**HaskoningDHV UK Ltd.
Mobility & Infrastructure**

To: Devinda Kumarasinghe, Oxfordshire County Council
From: Juliet James
Date: 09 February 2024
Copy: -
Our reference: PC5143-RHD-ZZ-XX-ME-R-0002
Classification: Project related
Checked by AF/AW

Subject: Parcel R, Kingsmere, Bicester (23/03073/HYBRID)

2.4m x 43m Visibility Splays

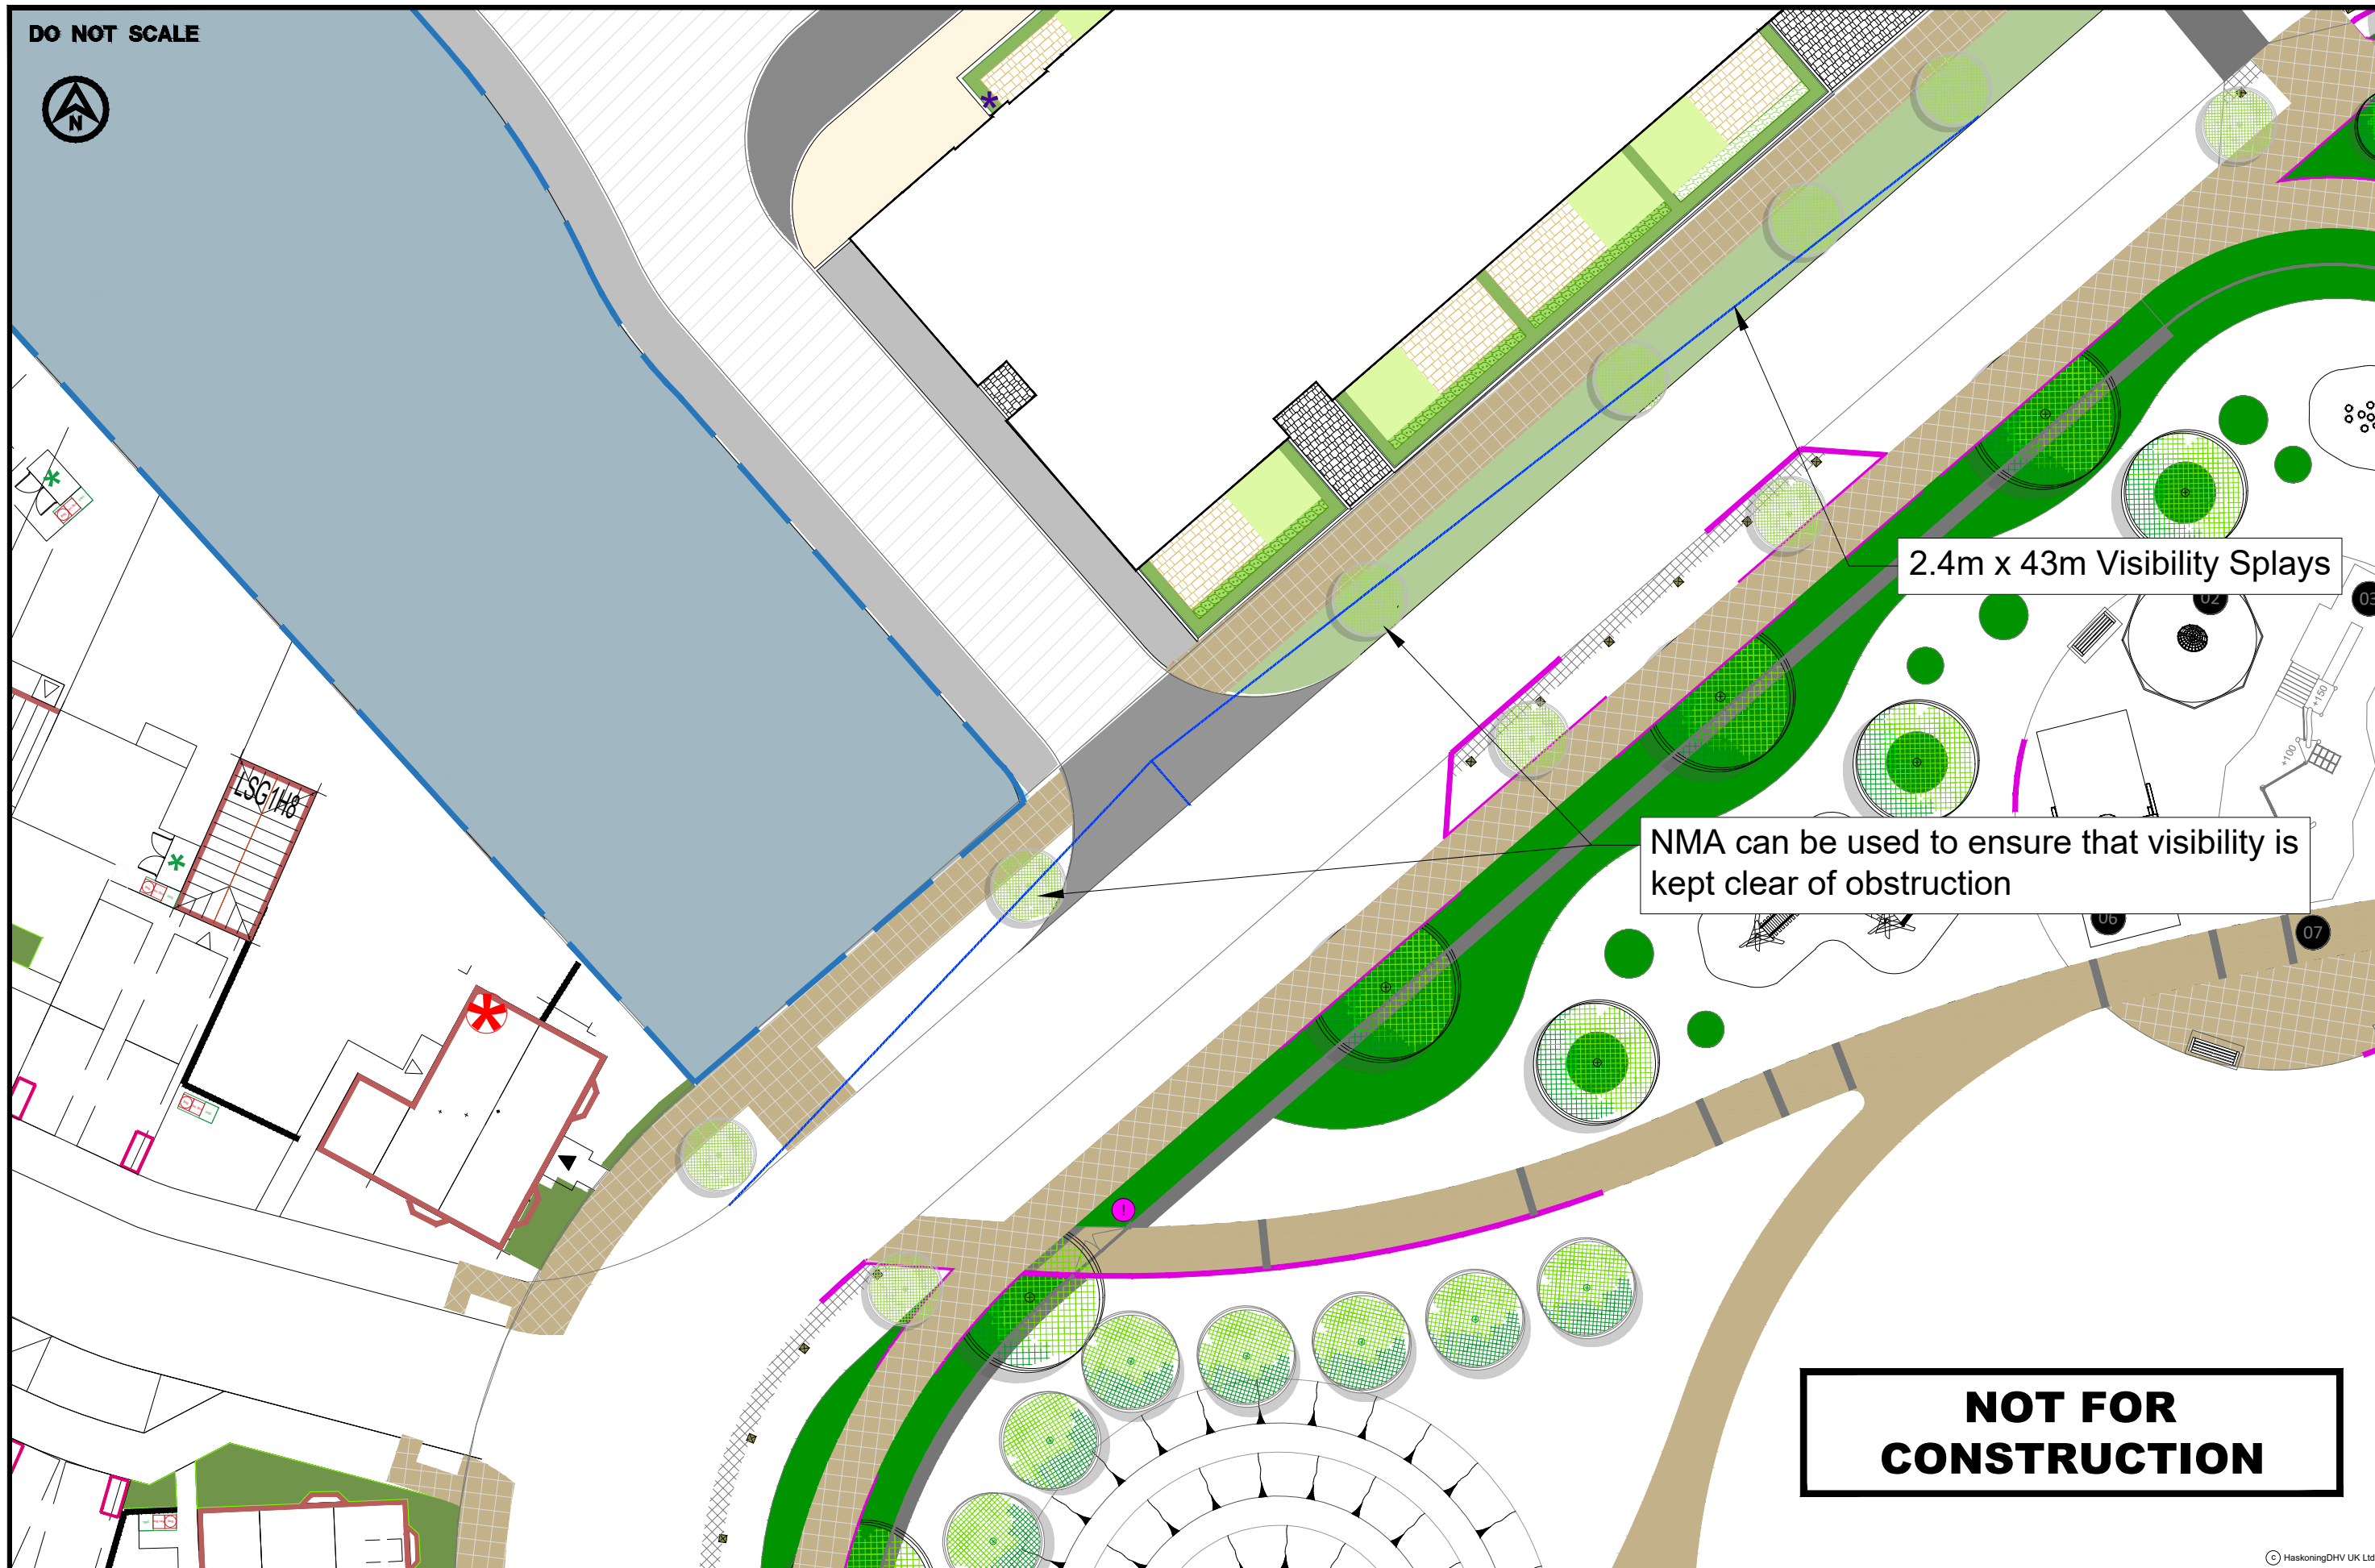
“Although the required safe visibility splays appear to be contained within the public highway there appears to be possible obstructions within it (e.g. shrubs / wall). The

visibility splay should be free of obstructions 2m high down to a point 600mm above the carriageway. Trees should not be positioned within visibility splays. It is noted that the applicant is willing to address this issue by ensuring that there is no obstructions within the visibility splays.

- 3.4.1 An updated site access junction visibility assessment is provided at **Annex D** indicating the trees that will be repositioned to a suitable location outside of the visibility splays as part of the proposed development.

Drawing Title: Proposed Site Layout Plan

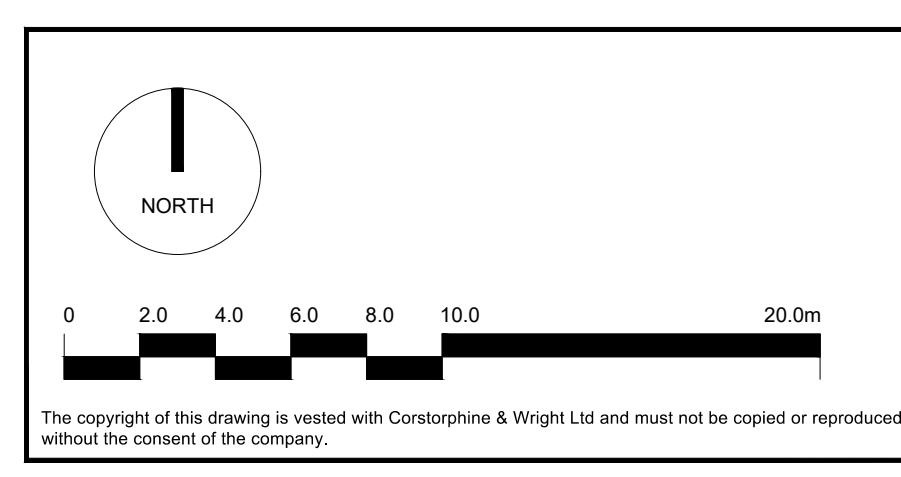
“The dimensioned site layout plan indicates some aisle widths of 4.63m near turning paths which is narrow for two-way vehicle movements. Safe two-way vehicle movement has not been demonstrated.”

“As set out within OCC’s ‘Parking Standards for New Development,’ active charging points for electric vehicles should be provided at a minimum level of 25% of all parking spaces with passive provision for all remaining spaces. In relation to parking for people with impaired mobility this should be provided at 6% of total spaces”

- 3.2.1 An updated proposed Site Layout, and a dimensioned plan of the on-site vehicular circulation and parking areas, is included in **Annex B** which incorporates adjustments to provide additional carriageway width at both. Swept path analysis indicating two-way movements for a large car within the updated site layout is included in **Annex C**.

- 3.6.1 As set out in the submitted Transport Statement and indicated on the proposed site layout included at Annex B, 7 of the 28 parking spaces (i.e., 25%) are proposed to incorporate active electric vehicle charging points (EVCP). The proposed disabled parking provision of 3 spaces constitutes approximately 10% of the total parking provision and is in excess of the minimum requirement of 6%.
